Springwell Solar Farm - Responses to ExQ1 from North Kesteven District Council (ID 20054501)

TITLE:
 FIGURE 11.1: AGRICULTURAL LAND
 CLASSIFICATION (100m)

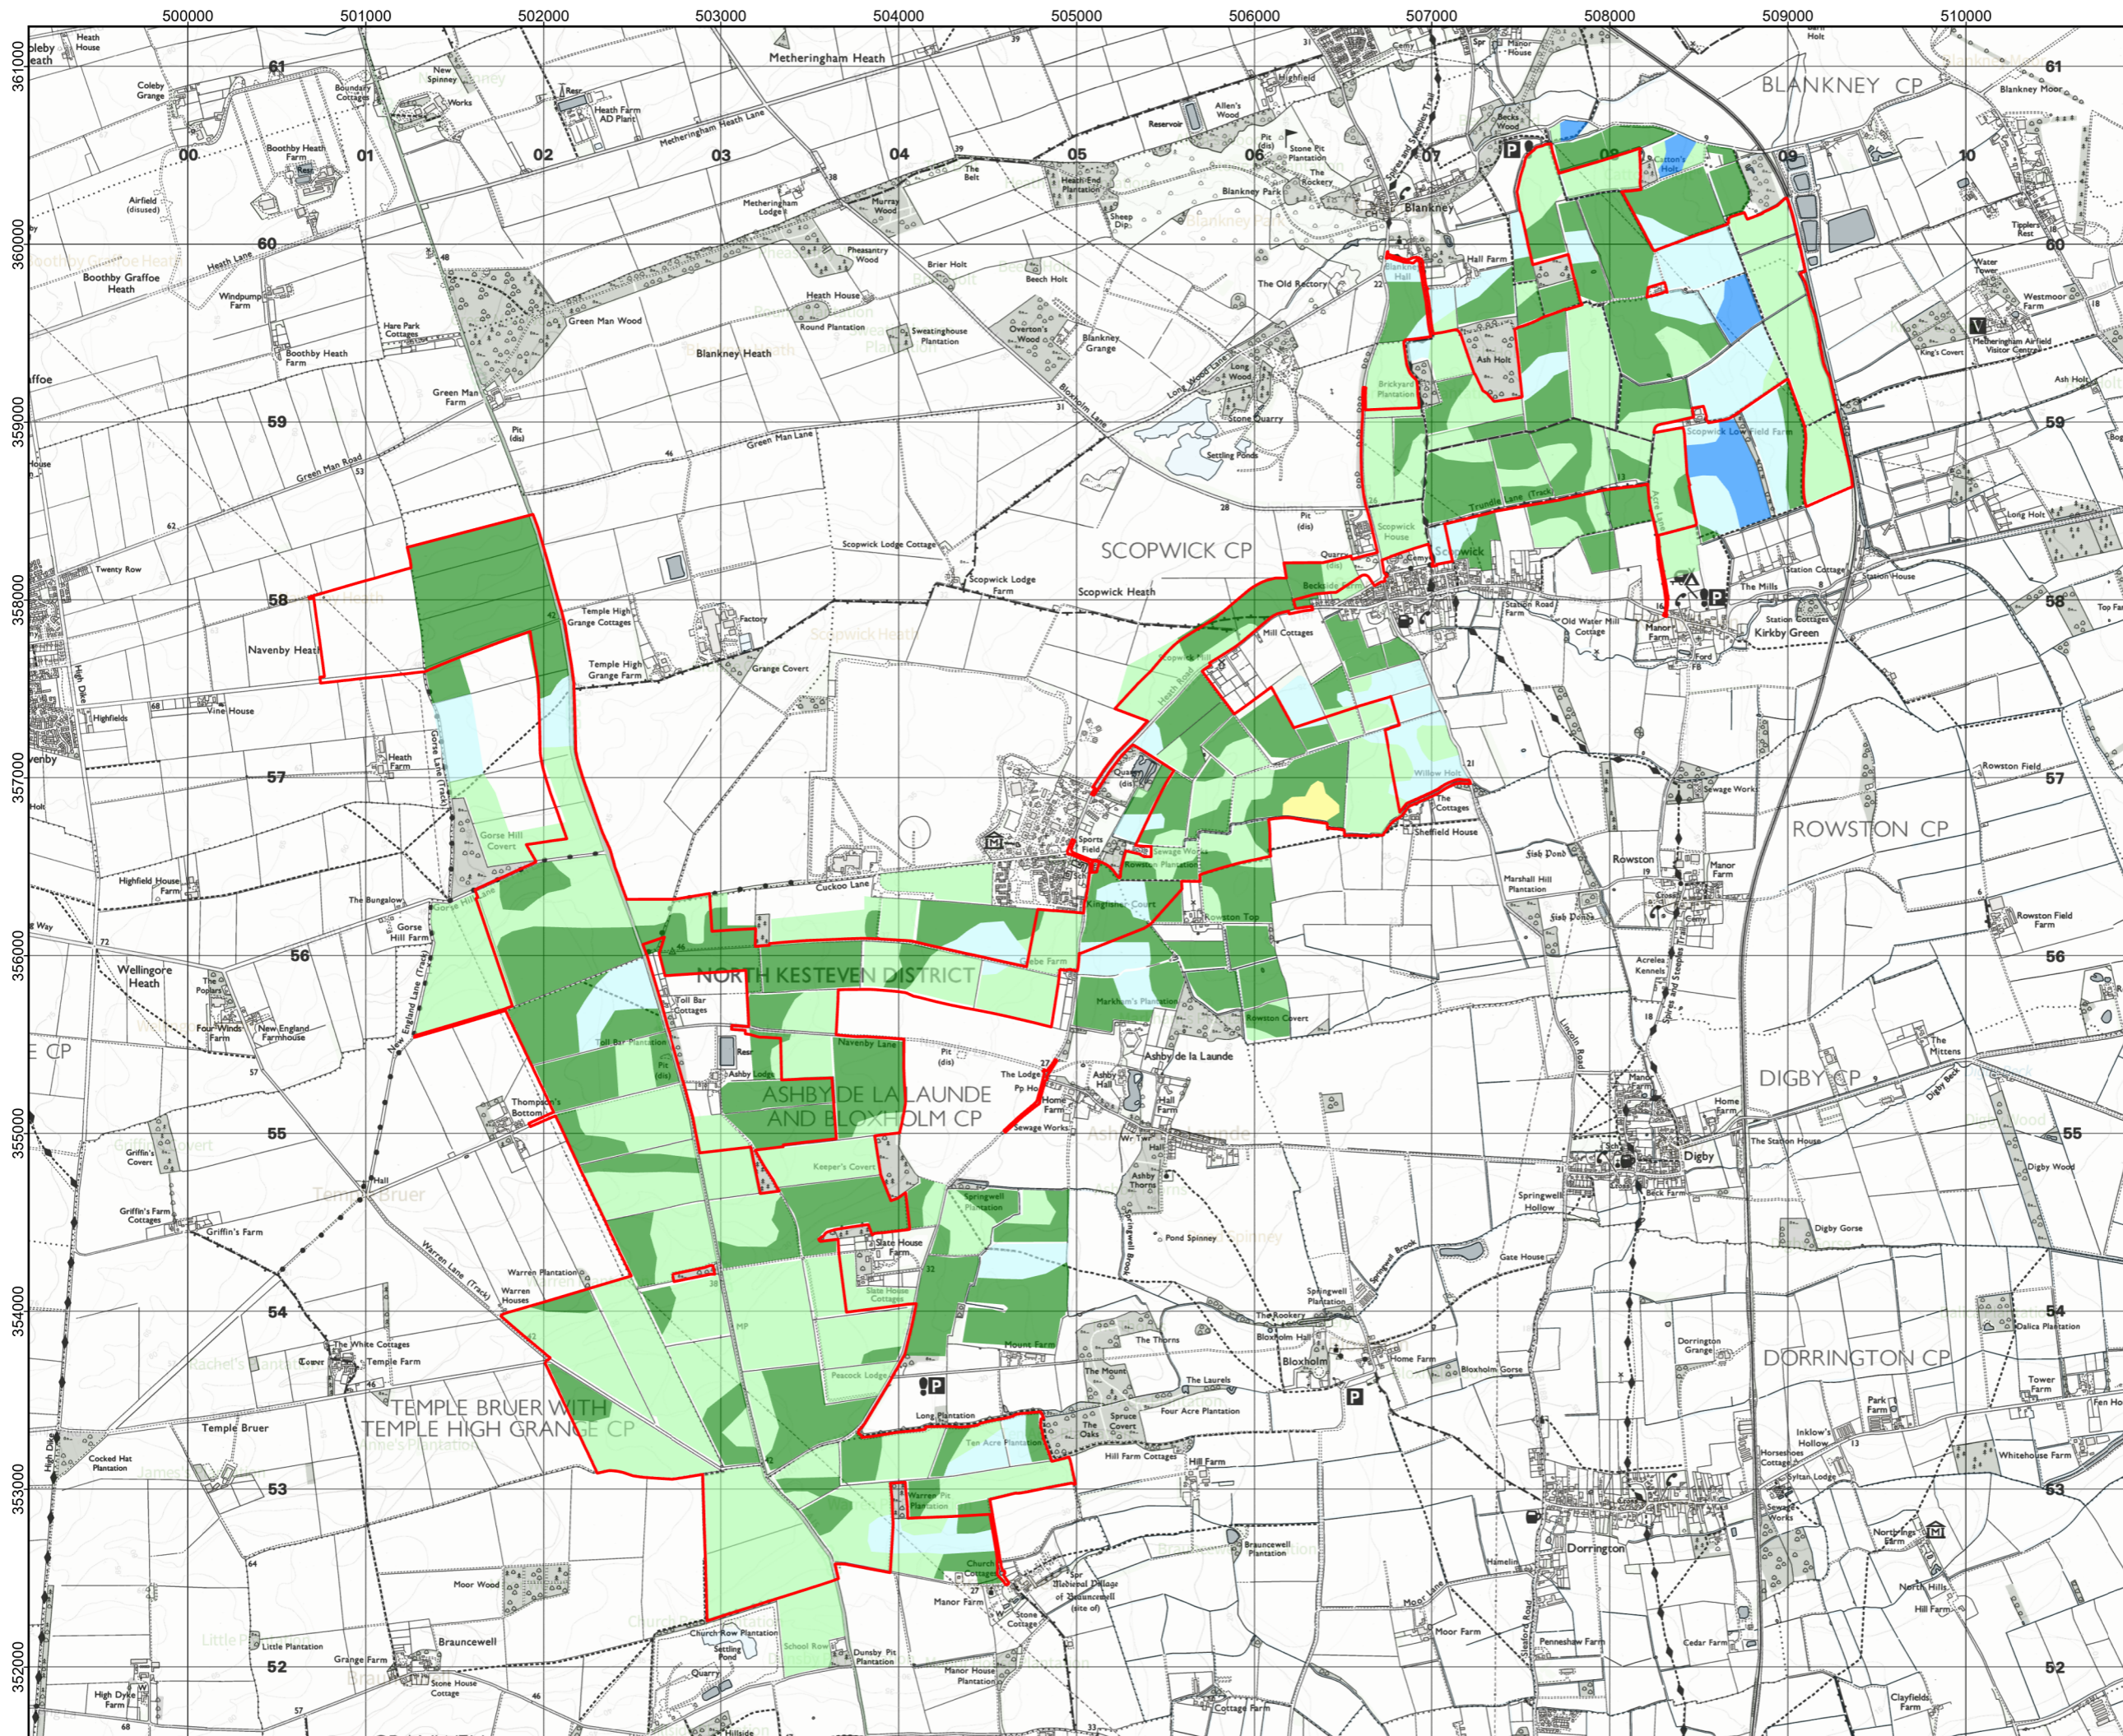
9. Land, Soils and Groundwater		
Q1.9.2	<p>Agricultural Land Classification Surveys</p> <p>The Applicant has undertaken Agricultural Land Classification (ALC) Surveys of the application site [APP-112 to APP-114]. NE [RR-291] has noted that the ES [APP-051, Table 11.12] presents a breakdown of land use across the Order limits,</p>	<p>b. In its LIR at paragraph 18.15, the Council agrees that the ALC surveys have been undertaken by a professional team in agreement with Natural England and are considered reliable.</p> <p>The Council, however, raises some concerns at paragraphs 18.17-18.21 of its LIR over the way that the ES has considered the impact of temporary uses (satellite collector compounds, BESS and Springwell substation and main collector compound) which would result in permanently ‘sealing over’ the land. We note that this is the subject of ExQ1.9.4. In its LIR at paragraph 18.20, the Council also raises a question over whether the provision of temporary green infrastructure in field Tb2 (through the formation of a bund to screen the substation and BESS) and a community growing area would be a further permanent loss of BMV agricultural land due to the change in land use over a 40 year period. In</p>

<p>but does not specifically categorise any construction compounds or access tracks.</p> <p>a. Applicant, confirm if construction compounds and access tracks have been taken into account in Table 11.12 and if so, where.</p> <p>b. Are LCC and NKDC content that the ALC surveys have been undertaken robustly?</p>	<p>total the temporary green infrastructure could account for a further 20ha loss of BMV land. This is not fully explained in the ES.</p>
Q1.9.5	<p>Cumulative Effects on Best and Most Versatile Agricultural Land</p> <p>The Applicant has set out [APP-056, Paragraph 16.8.9.] that it estimates the total area of BMV land within Lincolnshire to be over 410,000ha. Therefore, the Proposed Development would alone occupy some 0.13% of the BMV land in Lincolnshire and with the development of all the solar farms identified in the cumulative assessment [APP-056, Table 16.1] alongside the Proposed Development, approximately 2% of the county BMV land resource will be temporarily used.</p>	<p>These figures are not necessarily recognised by Natural England or DEFRA, but NKDC agree that if verified or confirmed they would be correct.</p>
